From: [Jayme Zold](#)
To: [Rachael Stevie \(CD\)](#)
Cc: [Dan Nelson](#)
Subject: RE: VA-20-00014 Fielder - Deemed Incomplete
Date: Monday, February 1, 2021 2:40:57 PM
Attachments: [Simpson Fielder Site and Section.pdf](#)
[image001.png](#)

From: Rachael Stevie (CD) [<mailto:rachael.stevie.cd@co.kittitas.wa.us>]
Sent: Monday, January 11, 2021 10:07 AM
To: lisa_kblast@hotmail.com; brian.fielder@hotmail.com
Cc: jayme@designsnw.com; Jeremy Johnston
Subject: RE: VA-20-00014 Fielder - Deemed Incomplete

① Site
 1" = 20'-0"

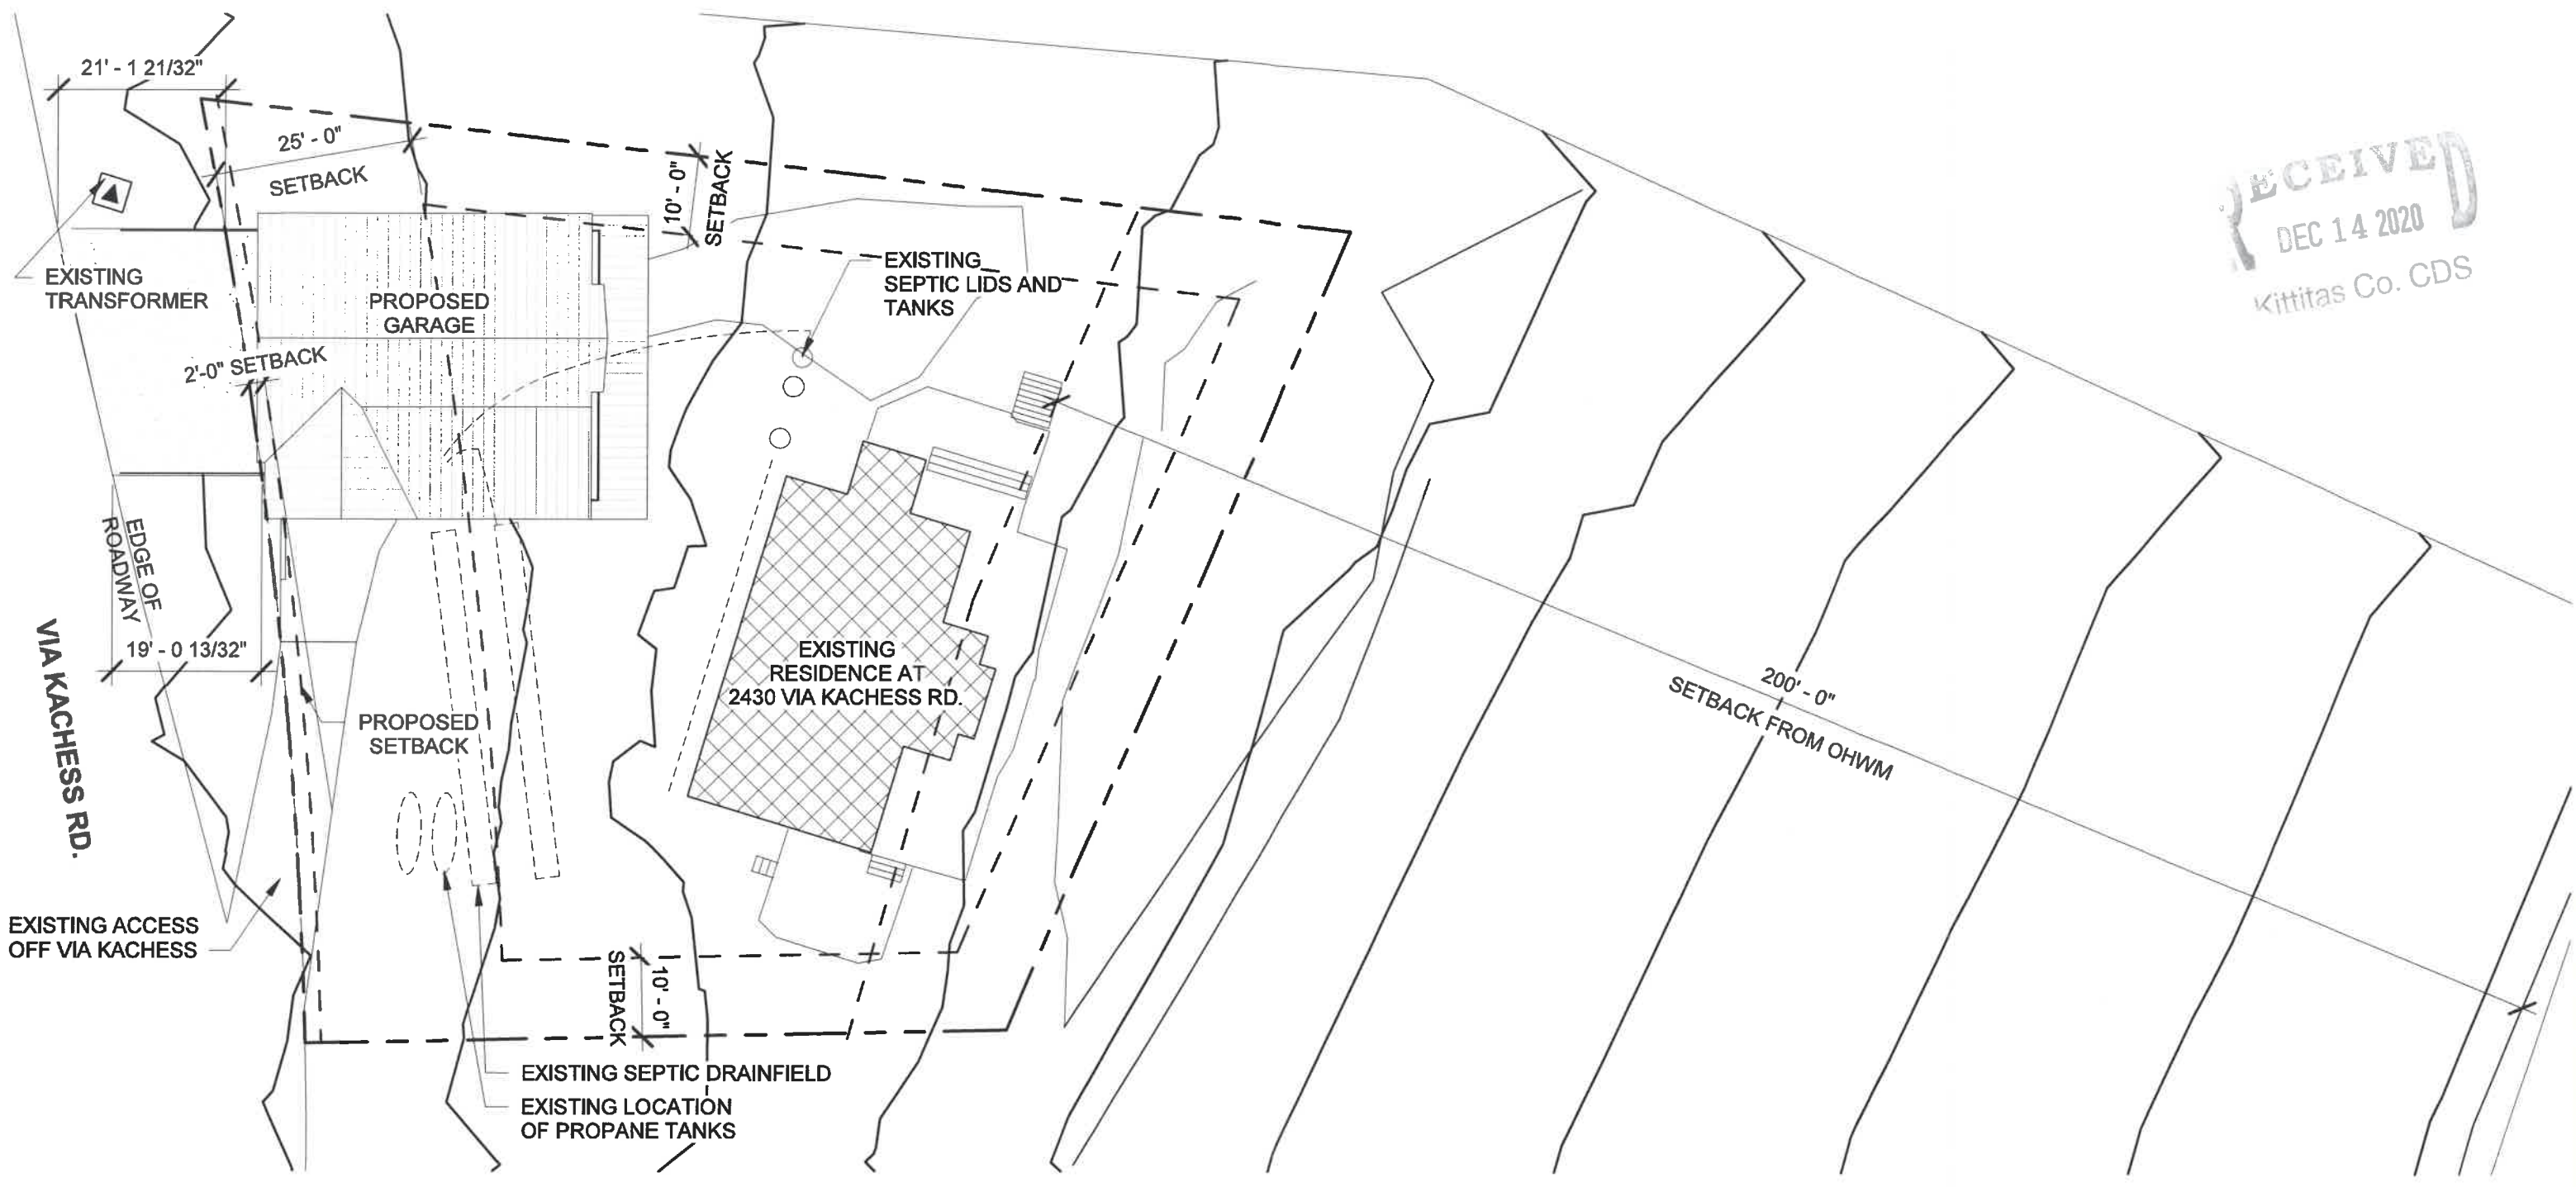
Thank you for this! Can you please add the 200' measurement from the OHWM on the horizontal site plan so commenting agencies will be able to clearly identify the distance from the project to the OHWM?
